2025/0609

St Hildas Church, Hanover Street, Thurnscoe, S63 0HJ

**Change of use of vacant church building (class F1) to storage (B8) and the installation of a 2m high paladin style fence and gate.**

2 Proposed Block Plan
1 : 500

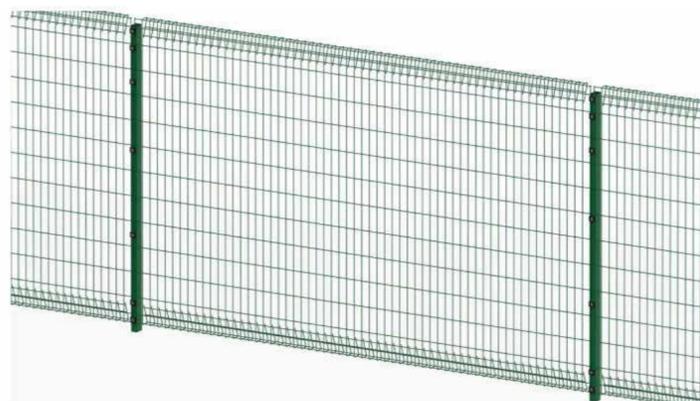
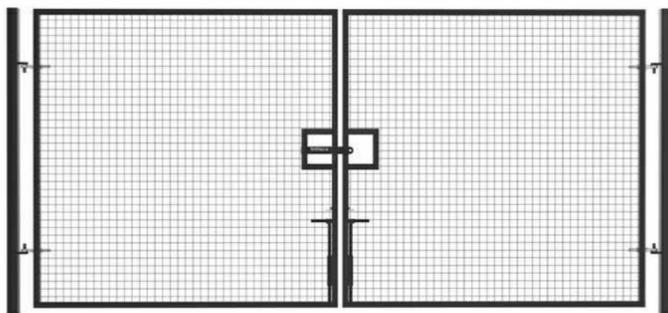
<b>Consultee</b>	<b>Summary of Response</b>
Highways DC	Requested the gates be set back 5m from the highway to minimise waiting time on the road whilst opening/closing the gates. This has been amended in line with the Highways Officers comments.
Local Ward Councillors	No comments received

The proposed gates have been amended to be set back from the Highway approximately 5m, this is to ensure that vehicles are not waiting on the roadside whilst opening/closing the gates. Highways DC raised no objections to the principle of the development and subject to a condition restricting the storage of large or bulky items to ensure items will not be delivered via hiab or articulated vehicles.
